August 22, 2016

RE: **Lot 23 Block 1 Unit 22 Volcano Cliffs Subd.
8004 Agua Fria Ct NW
Request for Permanent C.O. - Not Accepted
Engineers Stamp Date 5/18/16 (D10D003N23)
Certification Dated: 10/19/16**

GRADING AND DRAINAGE PLAN
LOT 23 , BLOCK 1 , UNIT 22 , VCS
ADDRESS: 8004 Agua Fria Ct NW

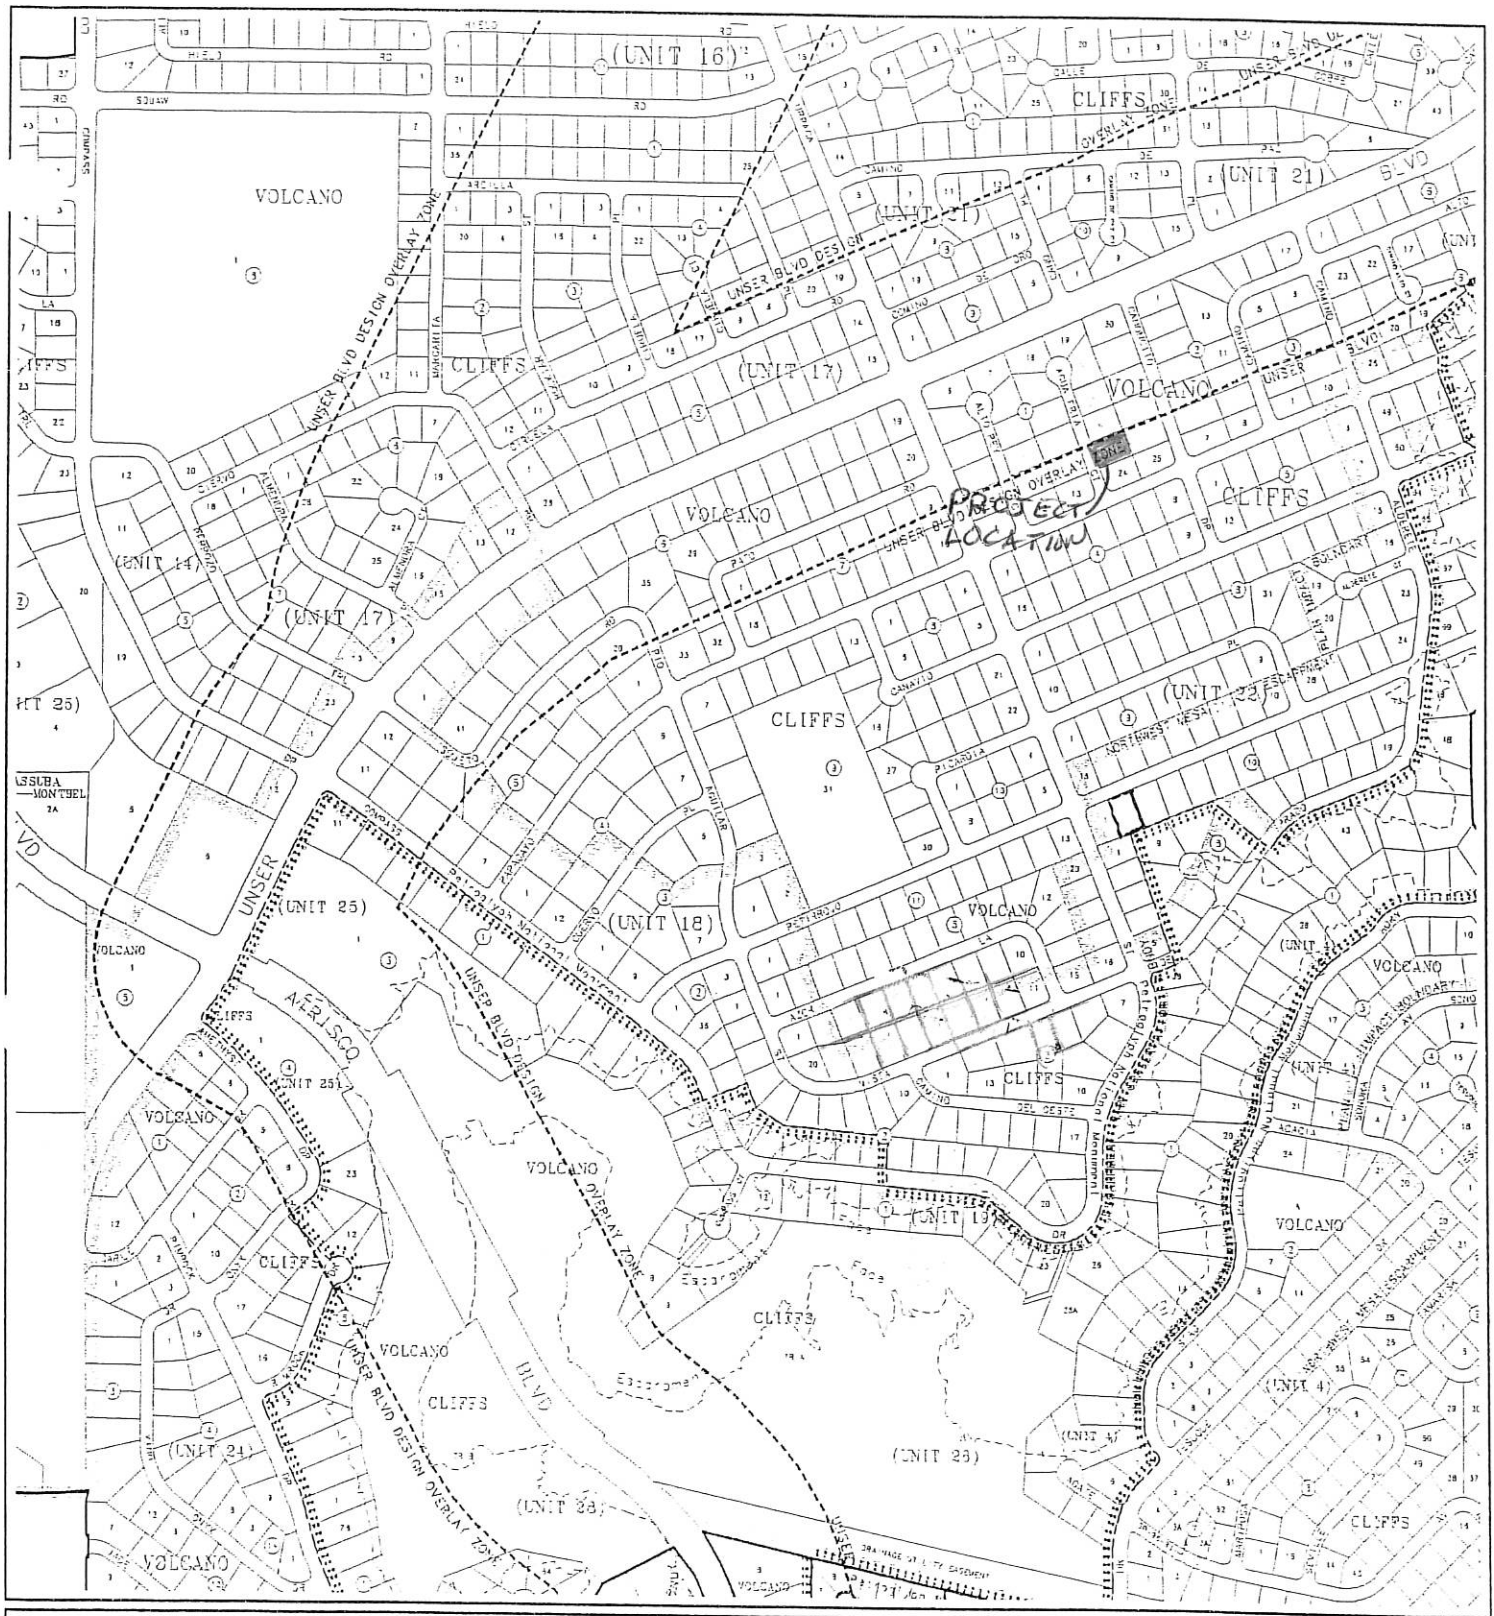
- Open trenches are filled
- Landscaping is complete
- Retaining walls with both turn block openings in backyard are missing
- Pond in NW corner of backyard is missing
